**Consultation Response from KC,  
Highways Development Management**

**2026/90829 Lumb Lane Nurseries, Lumb Lane, Almondbury, Huddersfield, HD4 6SZ**

**Discharge of details reserved by conditions 10 (CMP), 11 (retaining walls) 12 (CEMP), 14 (PWMS), 15 (ecology survey), 16 (invasive species) on previous permission 2025/92440 for erection of four dwellings**

These comments are only concerned with condition 10 as the others are out of the remit and technical reach of HDM. This application was accompanied by a Construction Management Plan Issue 01 from Heneghan Architecture and dated March 26 and a site layout drawing 2524-0404-P01.

Revisions		
P01	Preliminary Issue	24.03.26
Project:		
Residential Development		
at	Lumb Lane Nurseries Lumb Lane Almondbury	
for	North Park Homes Ltd	
Construction Plan - Layout		
Purpose of issue: PLANNING CONDITIONS		
Drawn	DRH	
Date	March 2026	
Scales	1:200 @ A2	
Drawing No.	2524 - 0404 - P01

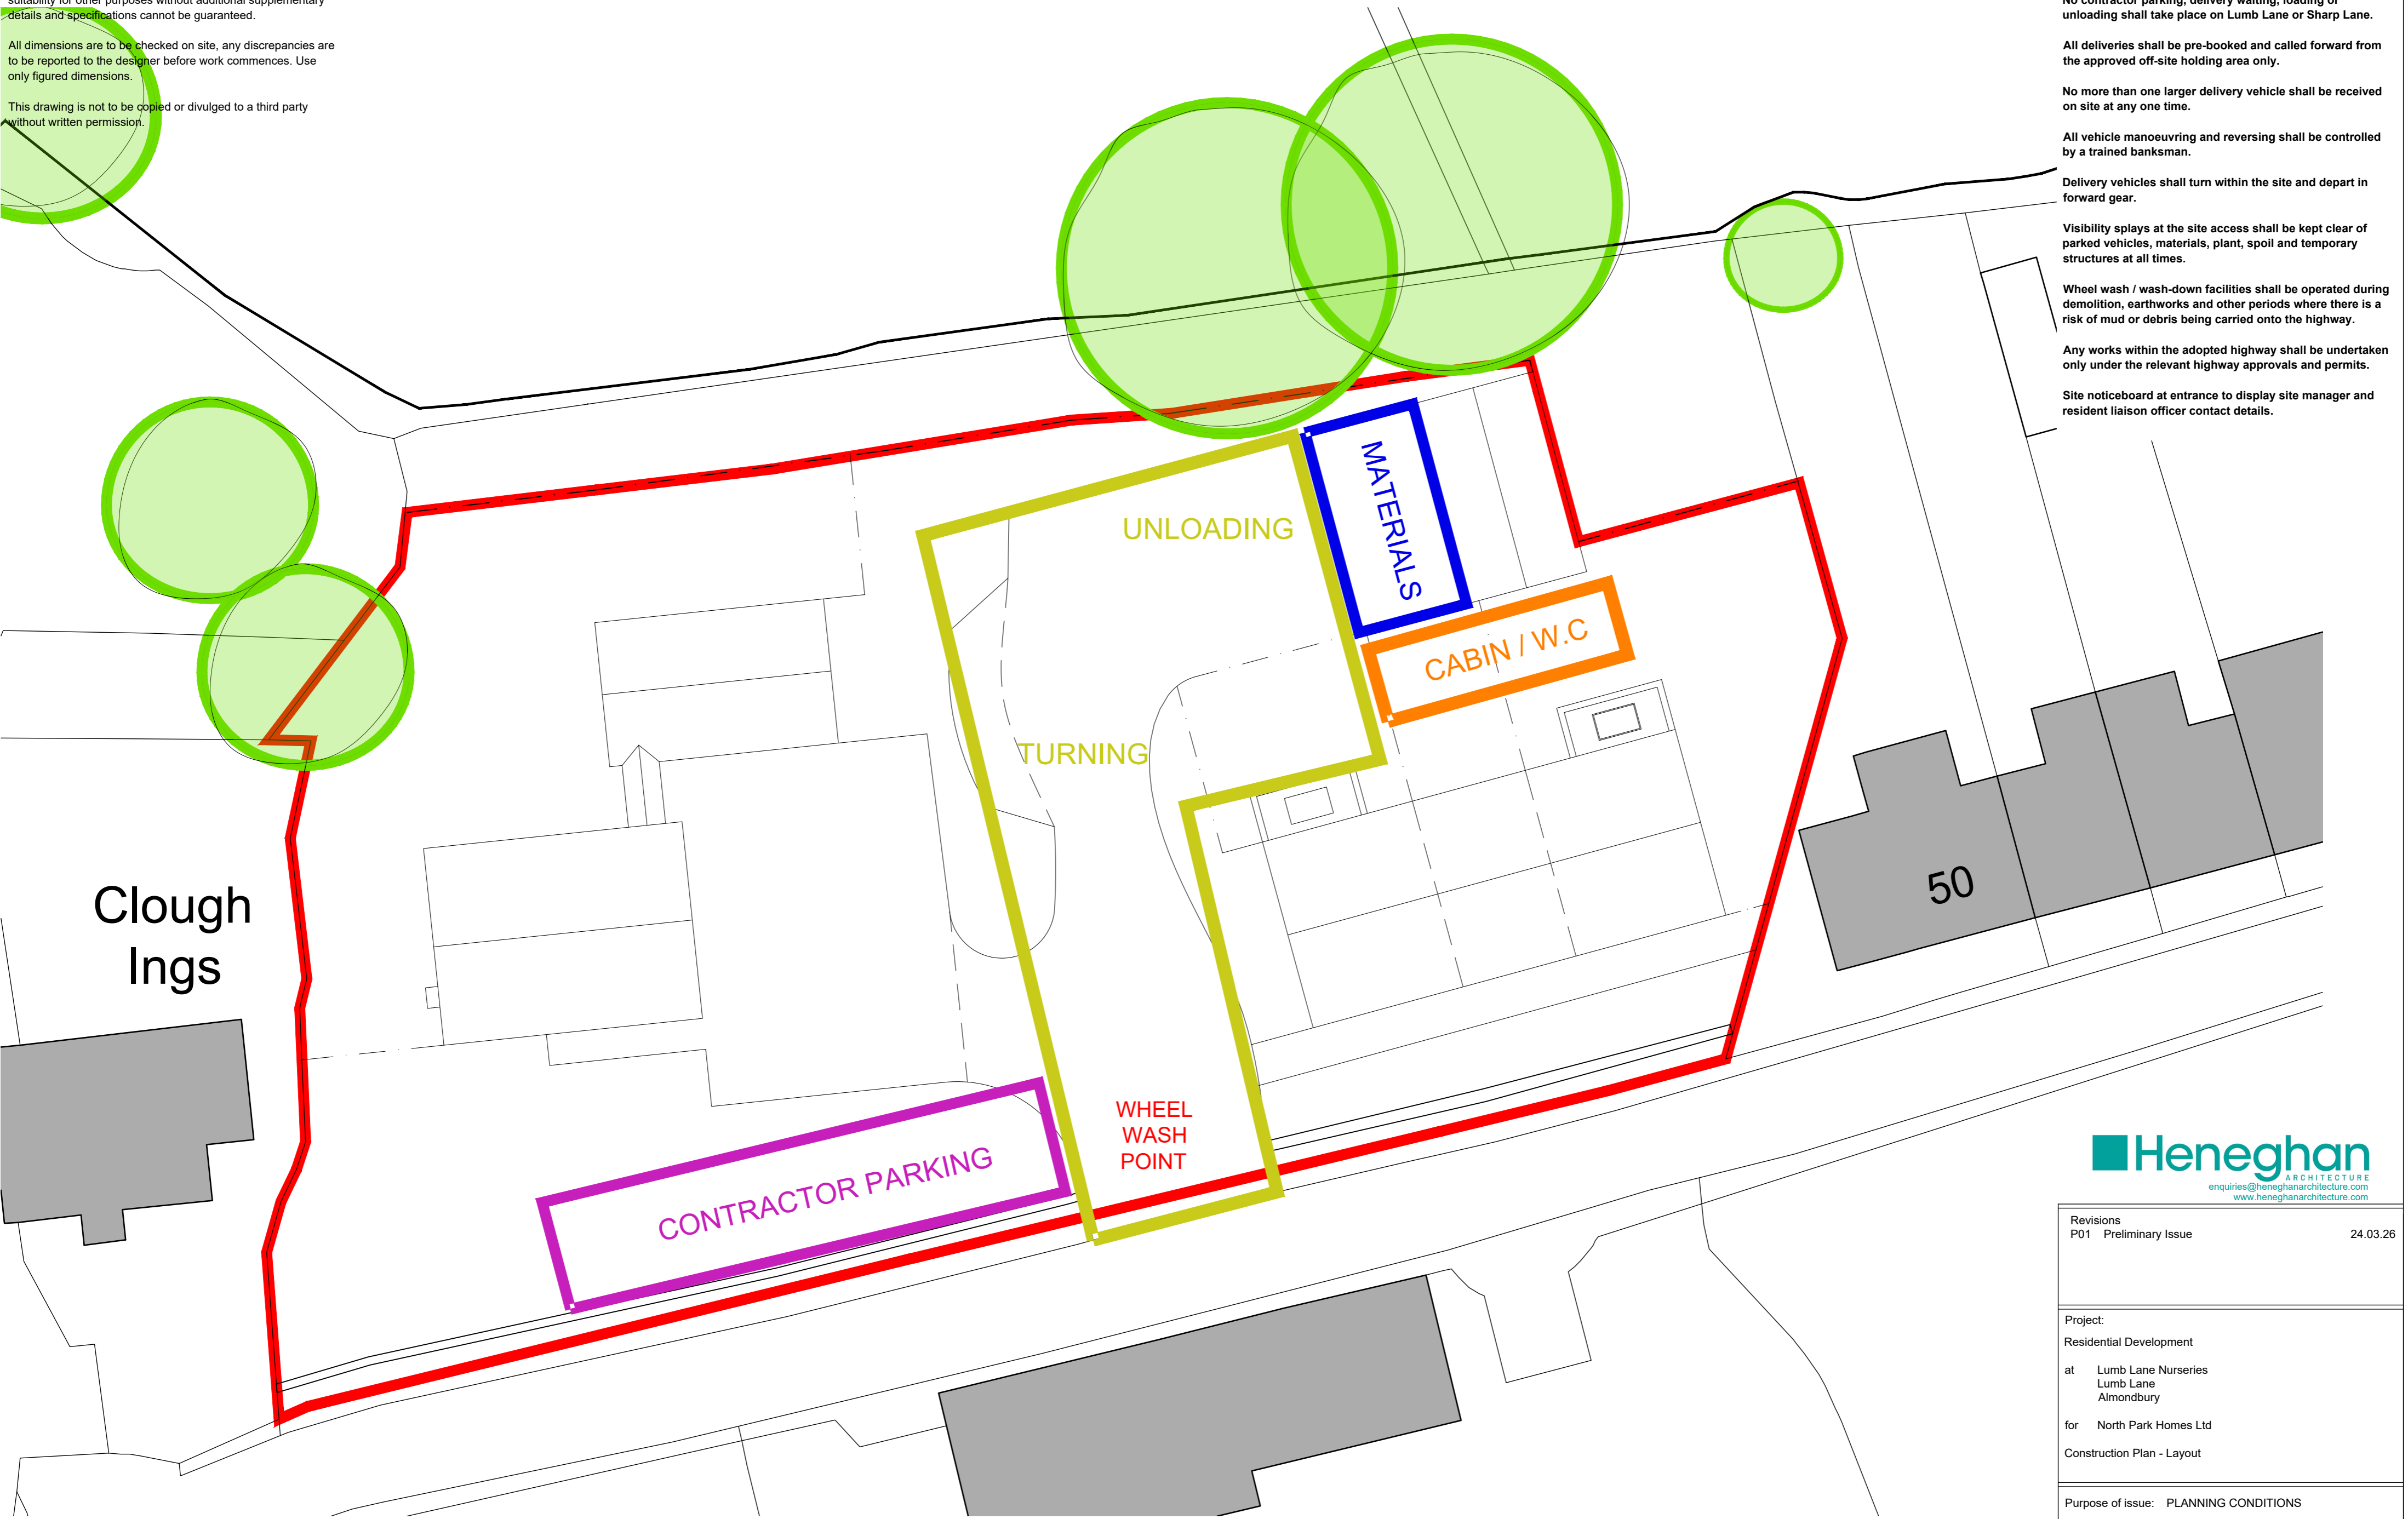
- f) Parking for construction workers;  
**This is detailed in section 5 and is shown on drawing 2524-0404-P01 and are acceptable**
- g) Loading and unloading of plant and materials;

**This is detailed in section 6 and is shown on drawing 2524-0404-P01 and are acceptable**
- h) Storage of plant and materials;  
**This is detailed in section 6 and is shown on drawing 2524-0404-P01 and are acceptable**

**This is detailed in section 8 with the location of the wheel washing facilities shown on drawing No 2524-0404-P01 and these are acceptable**
- k) Street sweeping;

With this we consider that the information provided within the CMP and site layout drawing 2524-0404-P01 is acceptable for the discharge of condition 10 of previous permission 25/92440.
